CITY OF ALBUQUERQUE

January 3, 2017

**Re: Bombs Away Beer Co.
9801 Acoma Rd. SE
Traffic Circulation Layout
Architect's Stamp dated 12-23-16 (L20-D070)**

A1.2

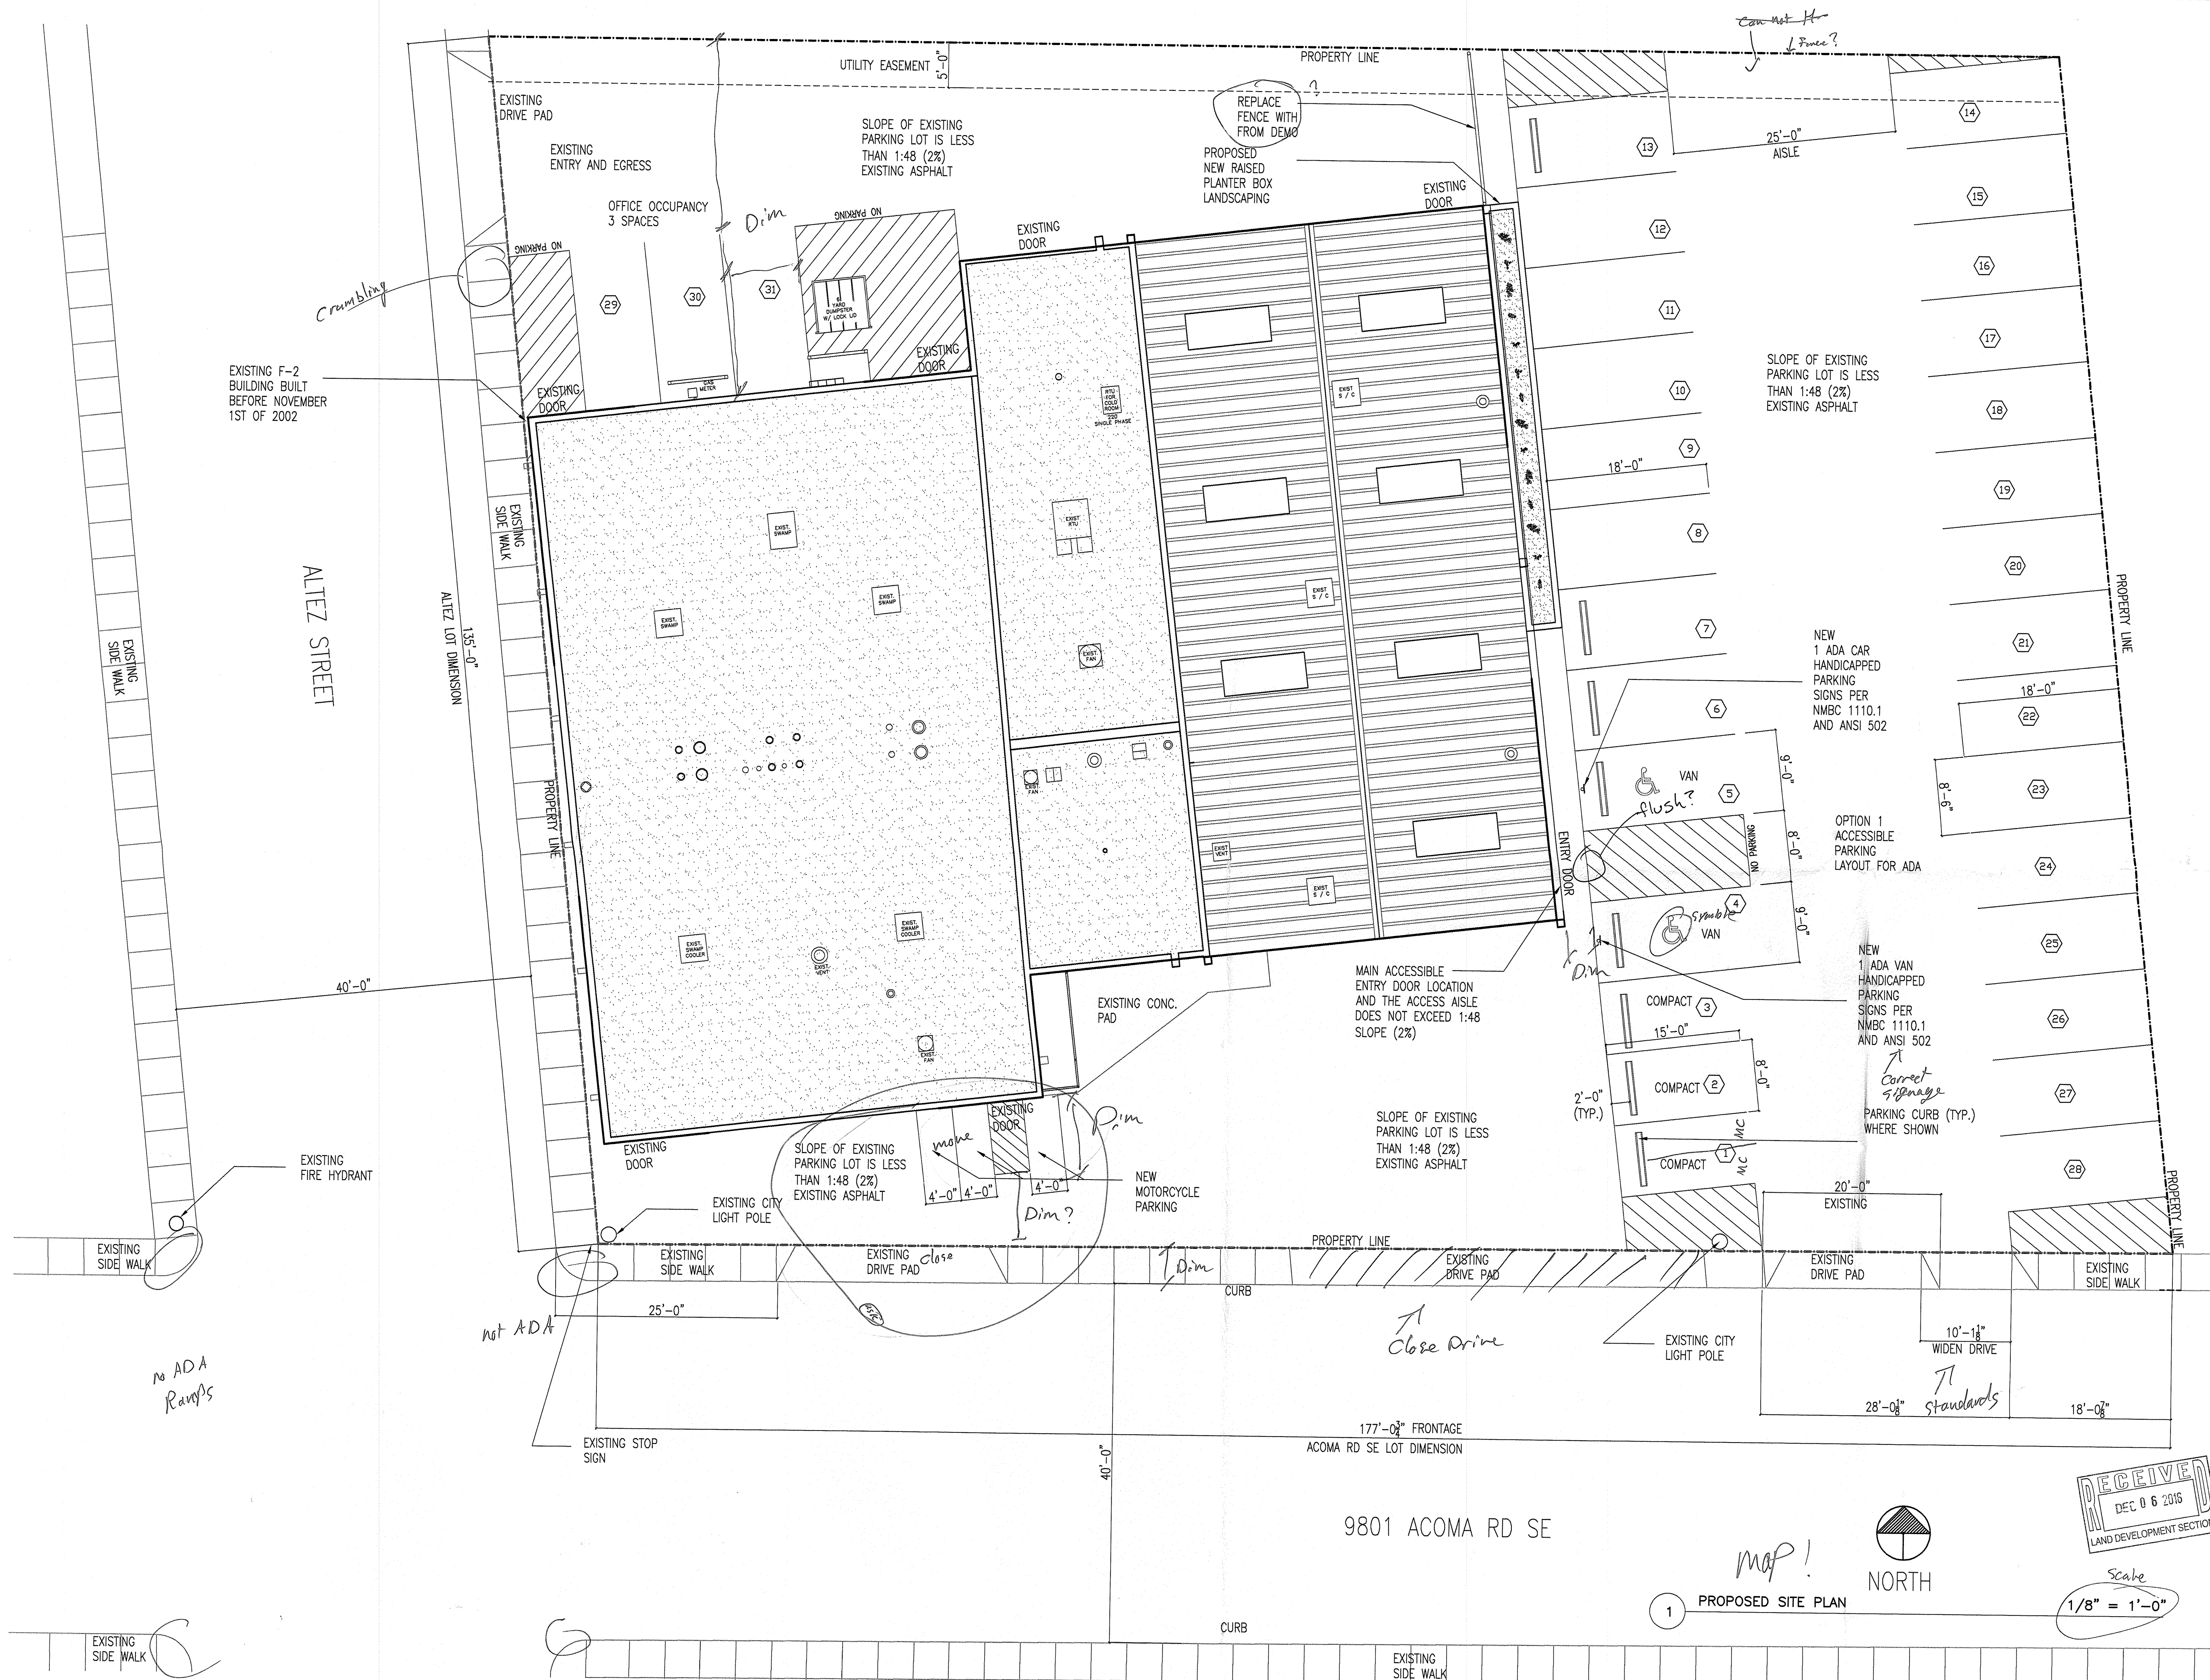
1. Please show a vicinity map showing the location of the development in relation to streets and well known landmarks.
2. A scale of 1"=20' is recommended for sites less than 5 acres per the Development Process Manual, Chapter 27, Section 2, Part B.1.

3. The traffic circulation layout must be stamped, signed, and dated by an engineer or architect licensed in the state of New Mexico.
4. Please identify all existing drive pad widths.

5. Please list the width and length for all existing and proposed parking spaces. Some dimensions are not shown. What are the dimensions of the parking stall in the back?

6. Label the compact parking spaces by placing the words "**COMPACT**" on the pavement of each space.
7. The ADA accessible parking sign must have the required language per 66-7-352.4C NMSA 1978 "**Violators Are Subject to a Fine and/or Towing.**" Please call out detail and location of HC signs.

8. The ADA parking space has a clearly visible, blue, International Symbol of Accessibility painted on the pavement at rear of the space (66-1-4.1.E NMSA 1978) or MUTCD recommends a white symbol on a blue background.

9. Show all drive aisle widths and radii. Some dimensions are not shown. Please dimension the distance from the parking stalls in the back to the end of the drive aisle, also dimension the aisle for the motorcycle parking.

10. Per the zoning code, a 6 ft. wide ADA accessible pedestrian pathway is required from the public sidewalk to the building entrances. Please clearly show this pathway and provide details or notes if it is flush with the entrance.

11. Per DPM, a 6 ft. wide ADA accessible pedestrian pathway is required from the HC parking stall access aisles to the building entrances. Please clearly show this pathway and provide details.
12. Please specify the City Standard Drawing Number when applicable.
13. Unused curb cuts must be replaced with sidewalk and curb & gutter. A build note must be provided referring to the appropriate City Standard drawing.
14. The second driveway on Acoma Rd must be closed. Please relocate the motorcycle and close the NW driveway on Acoma RD.
15. Add a note stating "All broken or cracked sidewalk must be replaced with sidewalk and curb & gutter." A build note must be provided referring to the appropriate City Standard drawing.
